From: Colin Sharpe
Sent: 09 July 2012 16:56
To: Jane Tucker
Subject: FW: Planning application consultation - 3/2012/0480P Workshop/office building Roaside Farm, Preston Road, Alston

From: Hornby, Mark [mailto:Mark.Hornby@lancashire.gov.uk]
Sent: 09 July 2012 15:38
To: Colin Sharpe
Cc: ENV EPP Customer Service Area East
Subject: FW: Planning application consultation - 3/2012/0480P Workshop/office building Roaside Farm, Preston Road, Alston

Proposed Site Layout

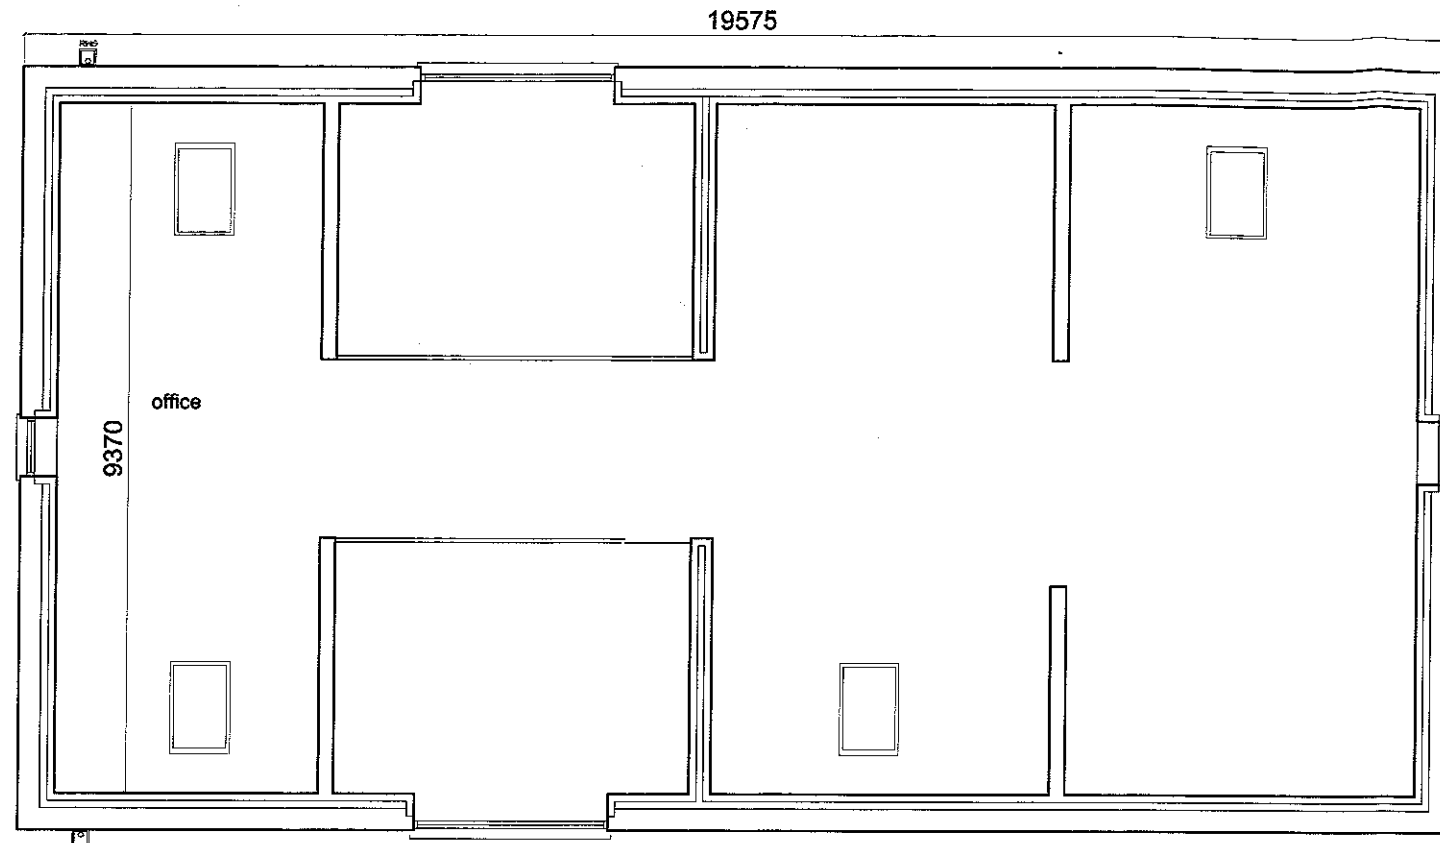
I have no objection to this proposal, however on visiting the site I noticed that loose gravel from the access driveway was being carried onto Preston Road. I would therefore ask for the following condition to be applied to any consent granted:

Before the access is used for residential purposes, that part of the access extending from the highway boundary for a minimum distance of 5 metres into the site shall be appropriately paved in tarmacadam, concrete, block pavements, or other approved materials. Reason: To prevent loose surface material from being carried onto the public highway thus causing a potential source of danger to other road users.
